PROPOSED REDEVELOPMENT OF COOP SMITHIES ACADEMY, HECKMONDWIKE – HIGHWAYS TECHNICAL NOTE 01 (4778) – NOVEMBER 2025

This Transport Note has been produced in response to the comments received from the local highways officers at Kirklees Council (KC), in their Consultation Response dated 29th October 2025 (Planning Ref: 2025/92598).

SWEPT PATH ANALYSIS - LOW LOADER - LEFT OUT

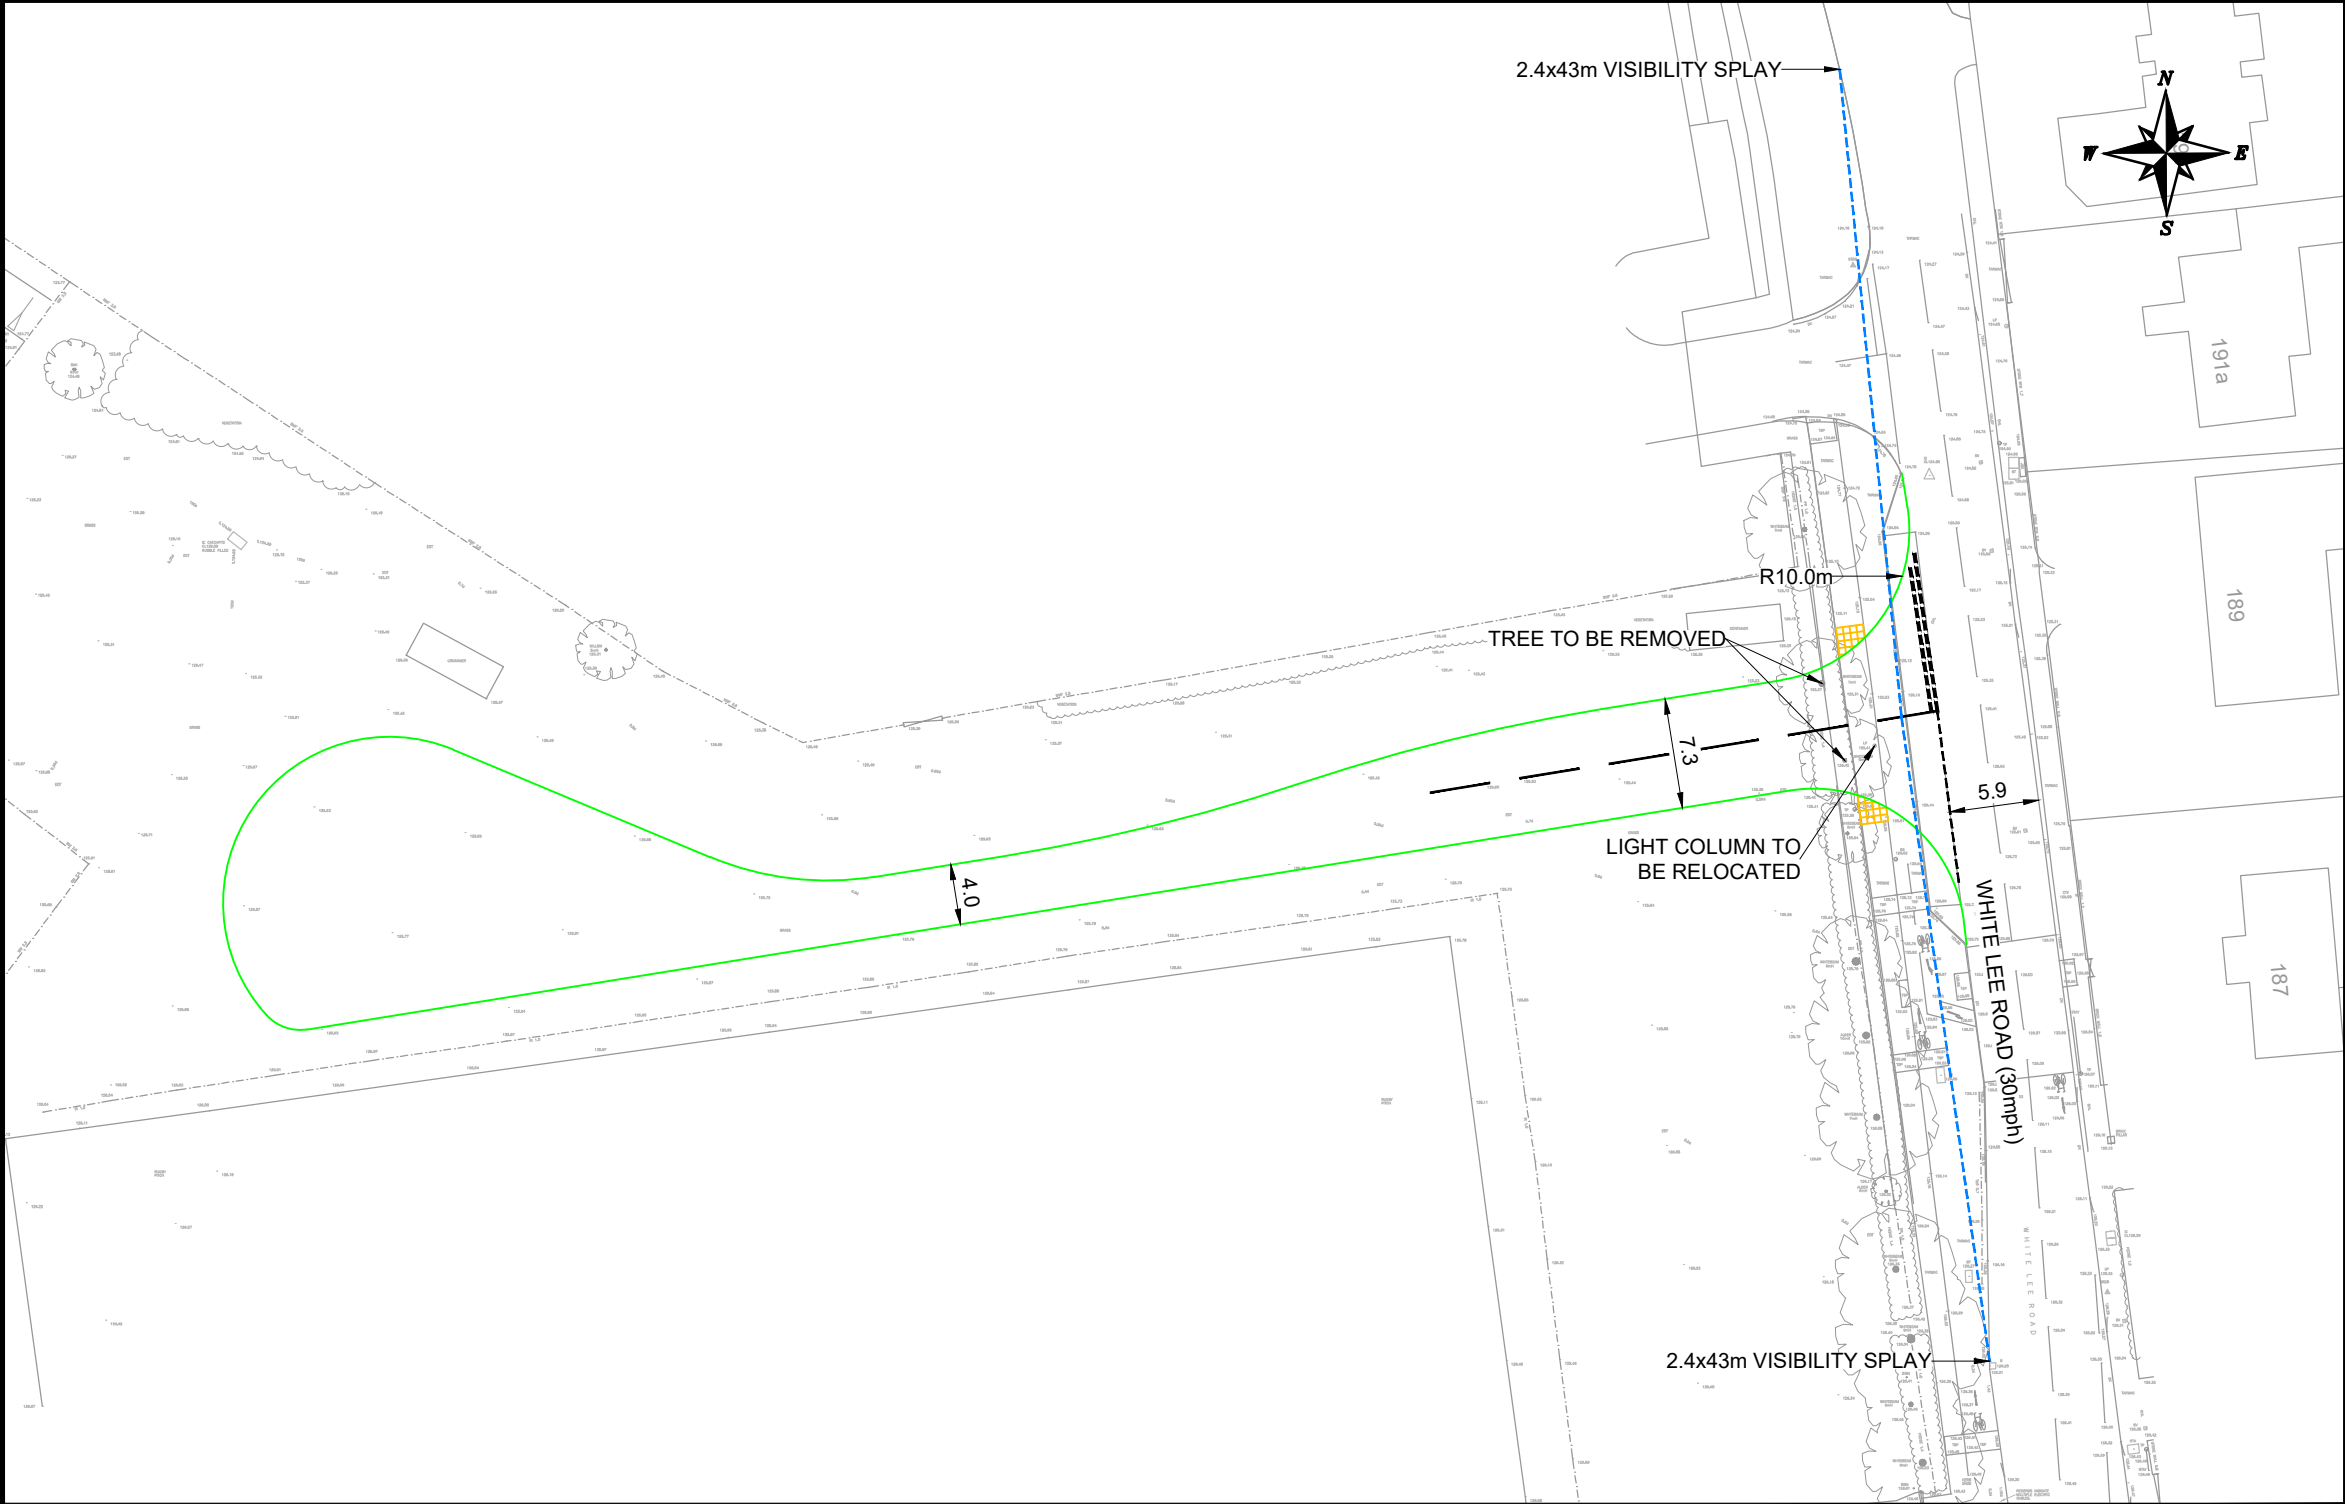
“HDM consider that the swept paths show that the access needs to be widened to allow comfortable turning and manoeuvre and access into and out of the site without crossing the Old Leeds Road centre line.”

Service vehicles will access and egress the site via Leeds Old Road, as they do at present there will be no changes to the servicing vehicle frequency or size as a result of the development proposals. Therefore, there are no requirements for any amendments to the existing access arrangement off Leeds Old Road.

With regard to the internal arrangements, the proposed internal arrangement is an improvement on the existing arrangement as a formal turning area is provided on site which will enable service vehicles to access and egress the site in a forward gear and not impact on the operation of the wider highway network.
